Your Ref: SSI 6878
Our Ref: Z17/442770
File: DE-2015/16
Date: 27 September 2017

ALBION PARK RAIL BYPASS STATE SIGNIFICANT INFRASTRUCTURE PROPOSAL (SSI 6878) – PREFERRED INFRASTRUCTURE REPORT

David Farmer
General Manager
Wollongong City Council
Telephone: (02) 4227 7111

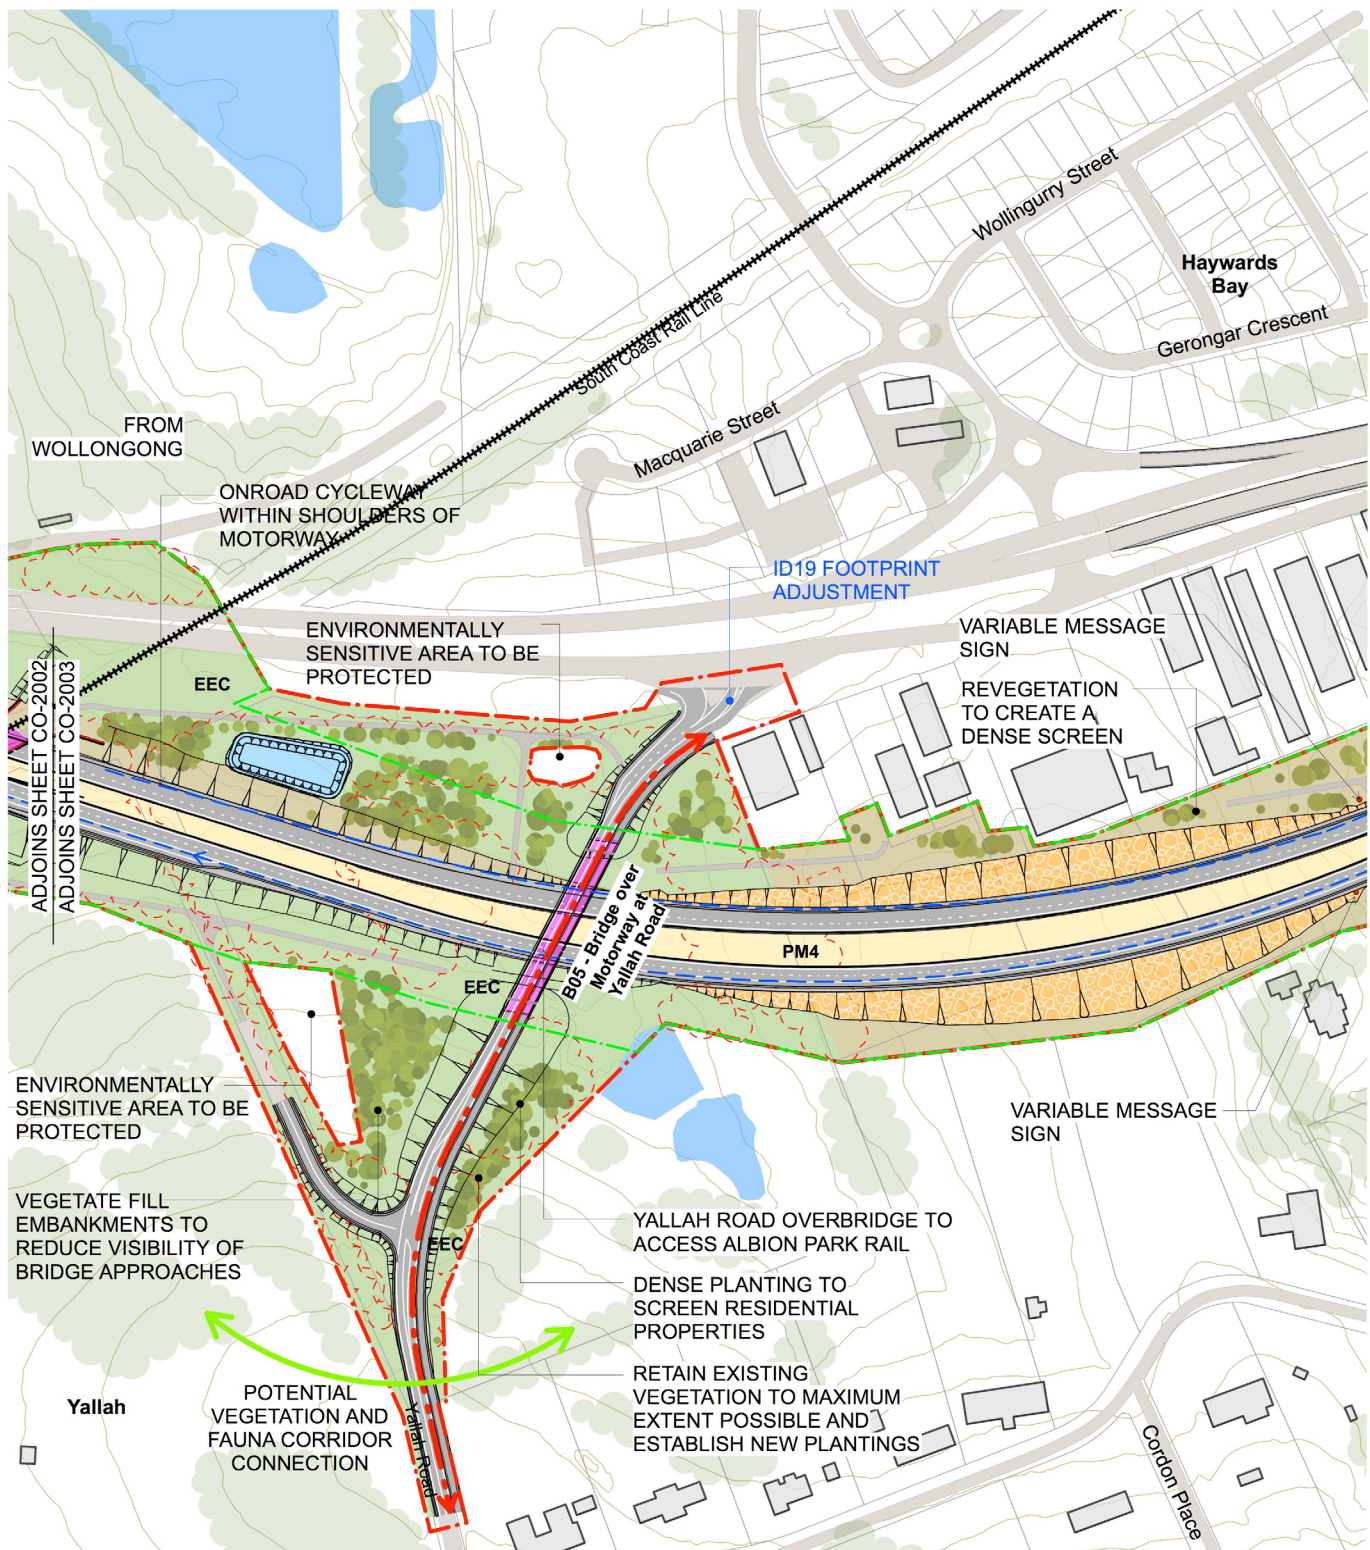
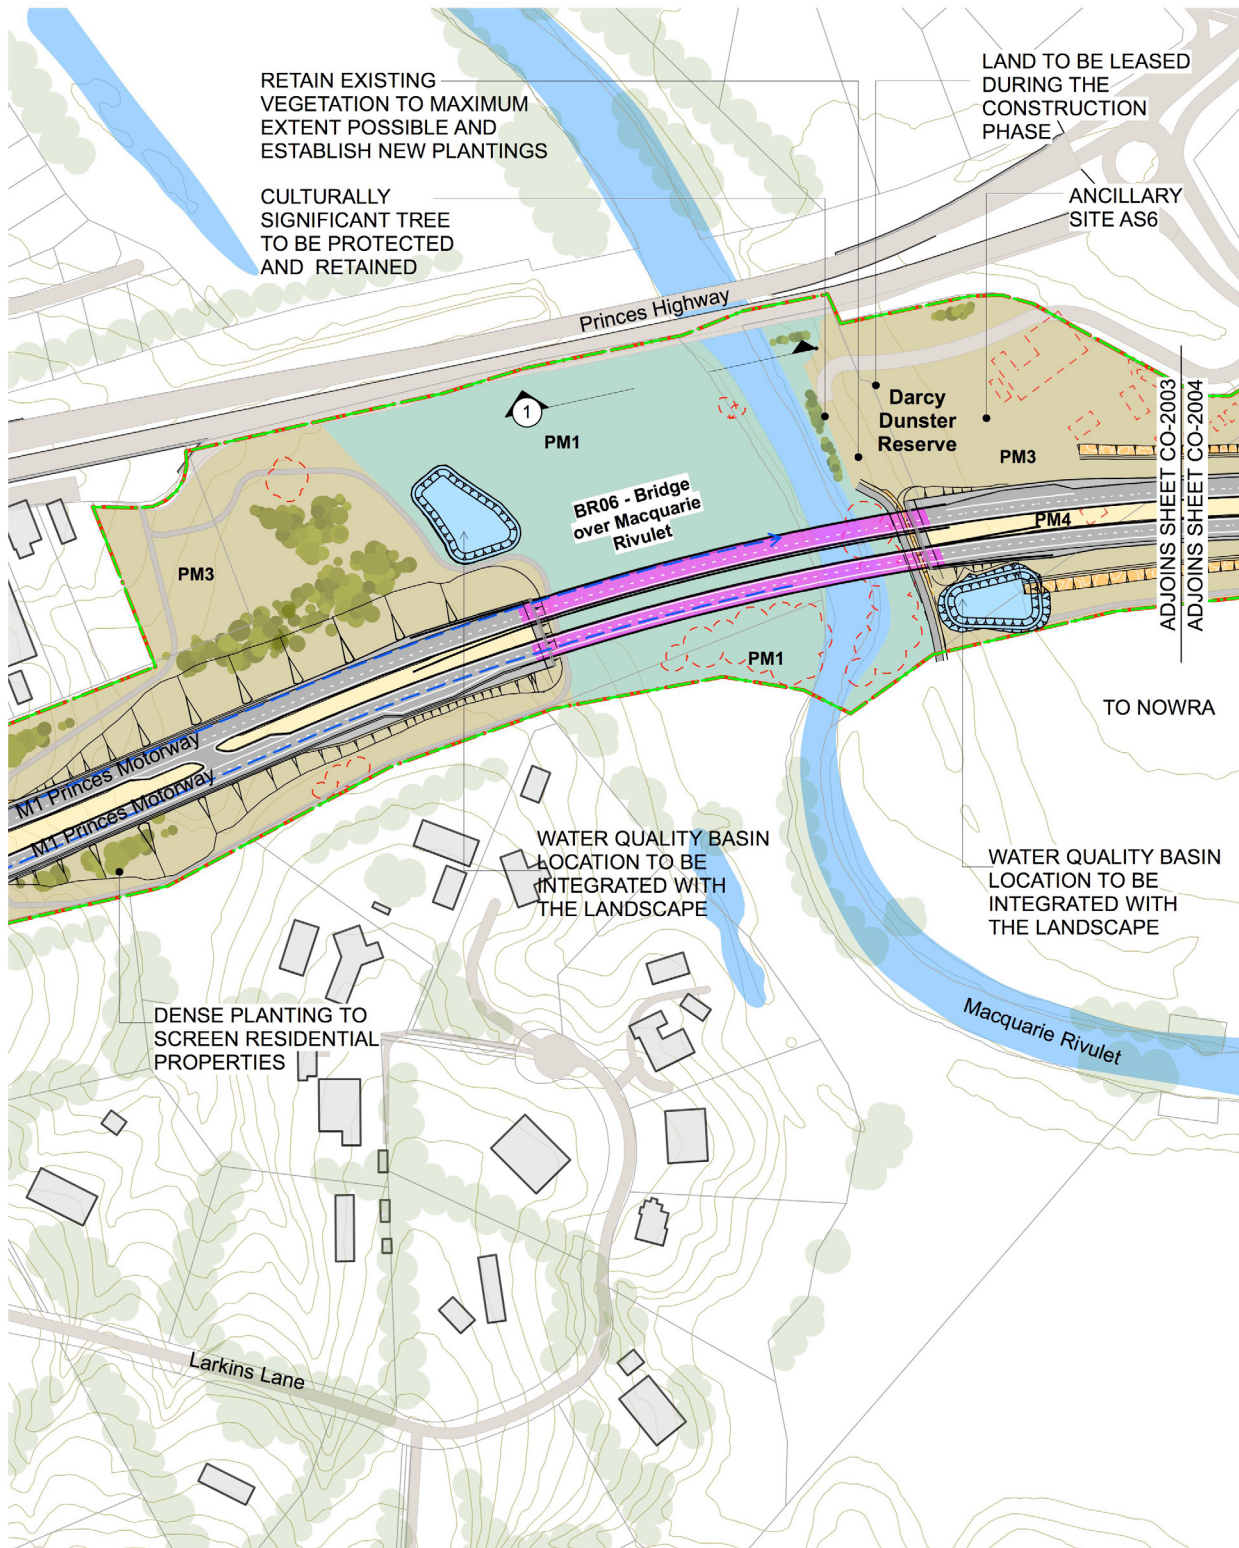
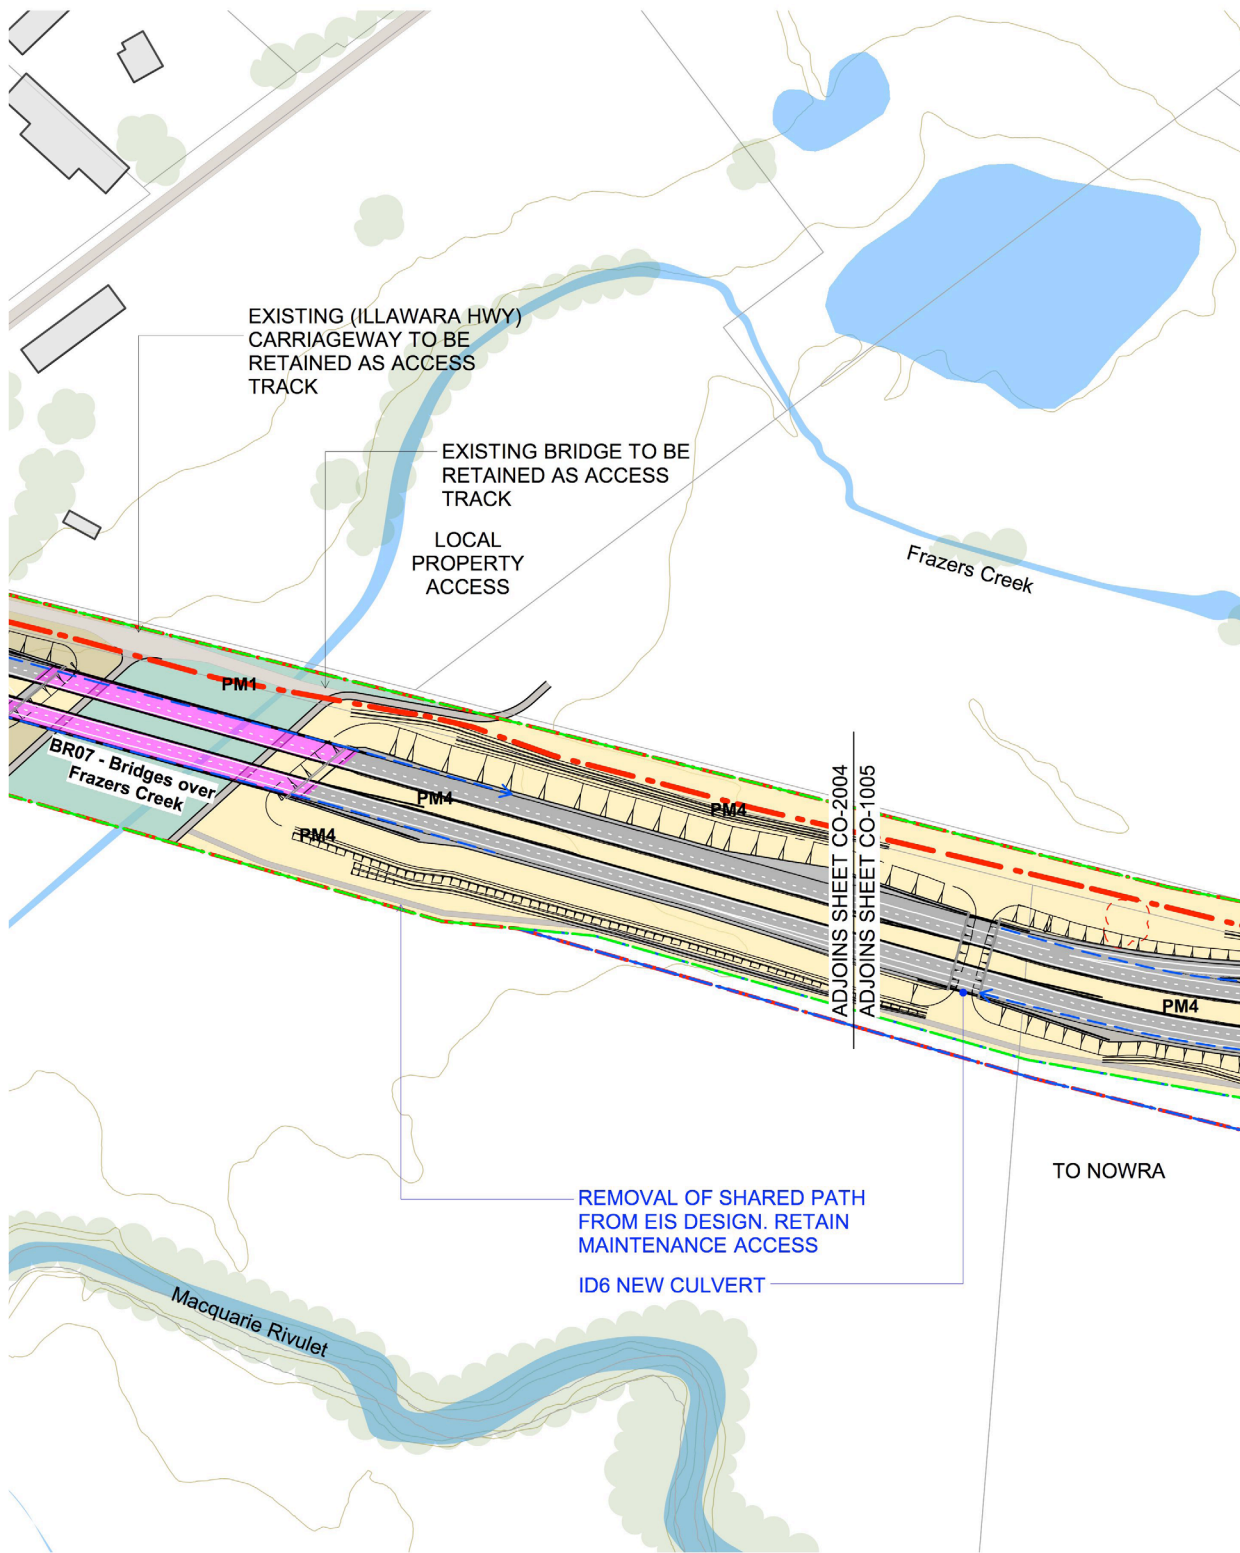
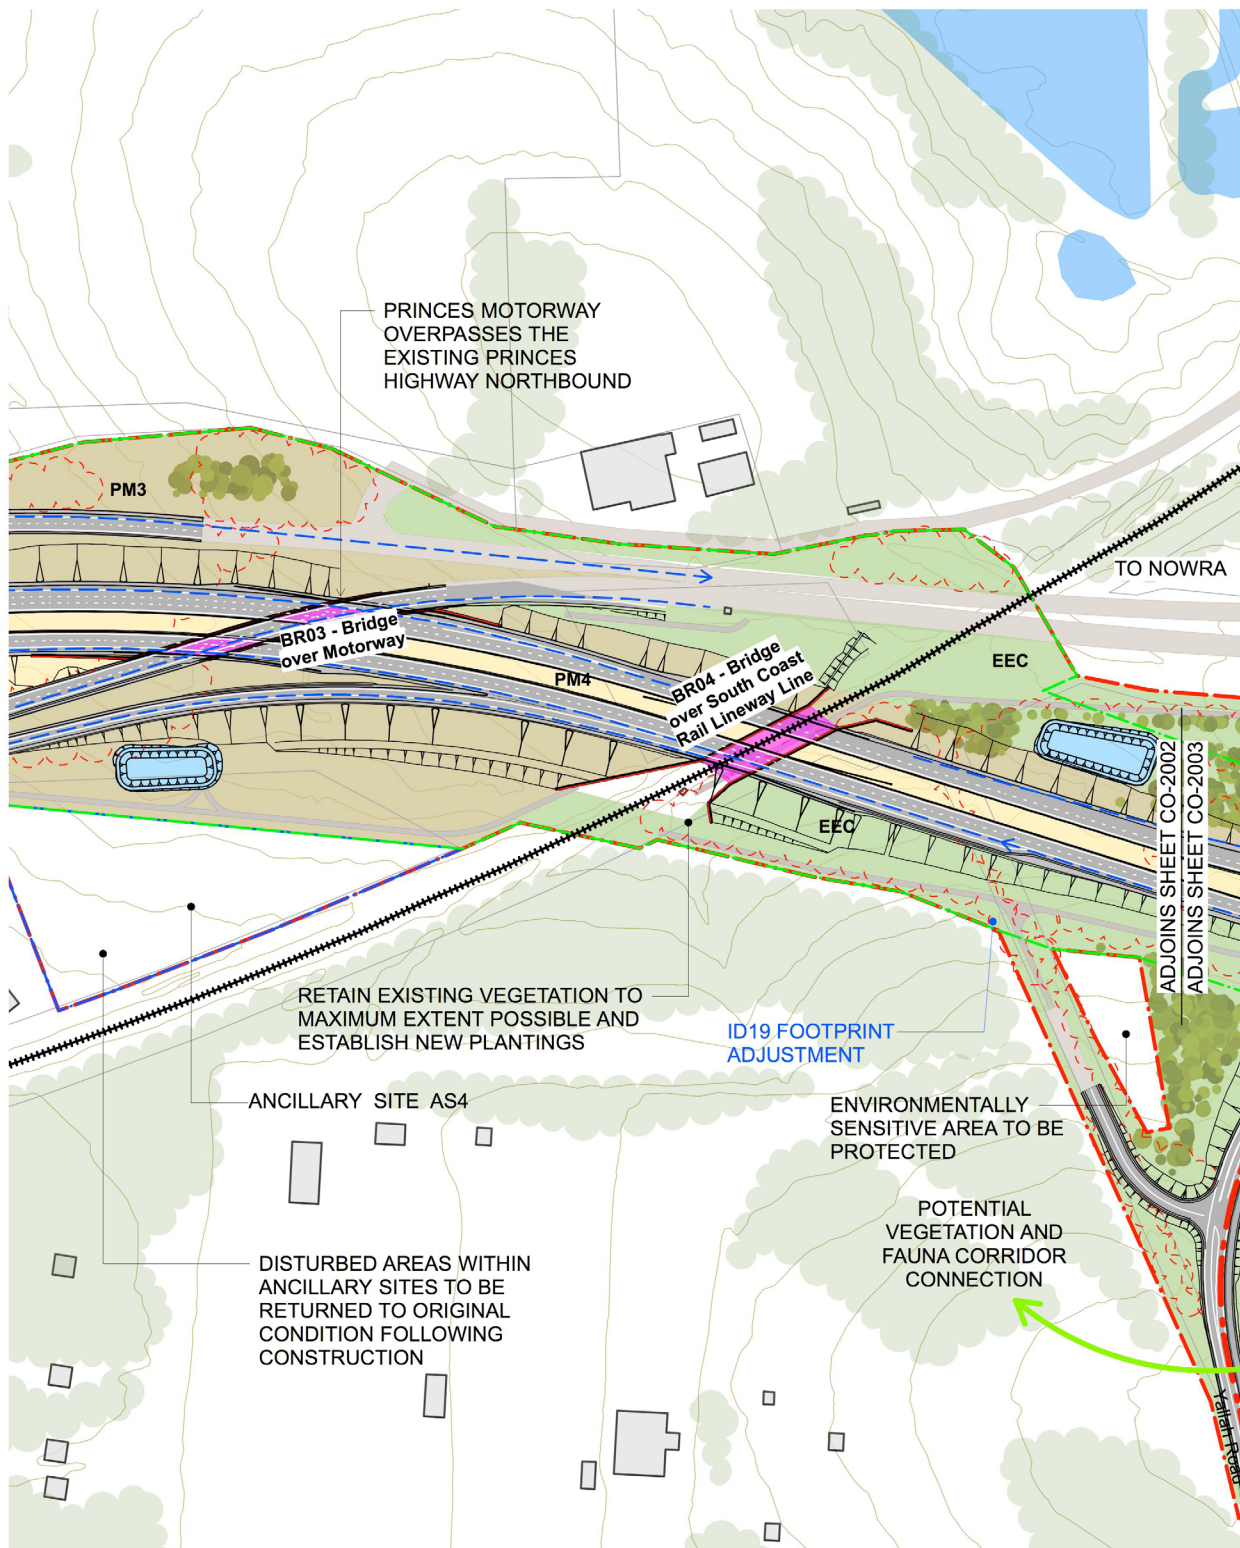
The final Landscape Plan should indicate all proposed tree removals, include compensatory provision for the trees required to be removed and include a more extensive list of natives grasses and groundcovers for proposed plant mix 2 (PM2)- feature planting.
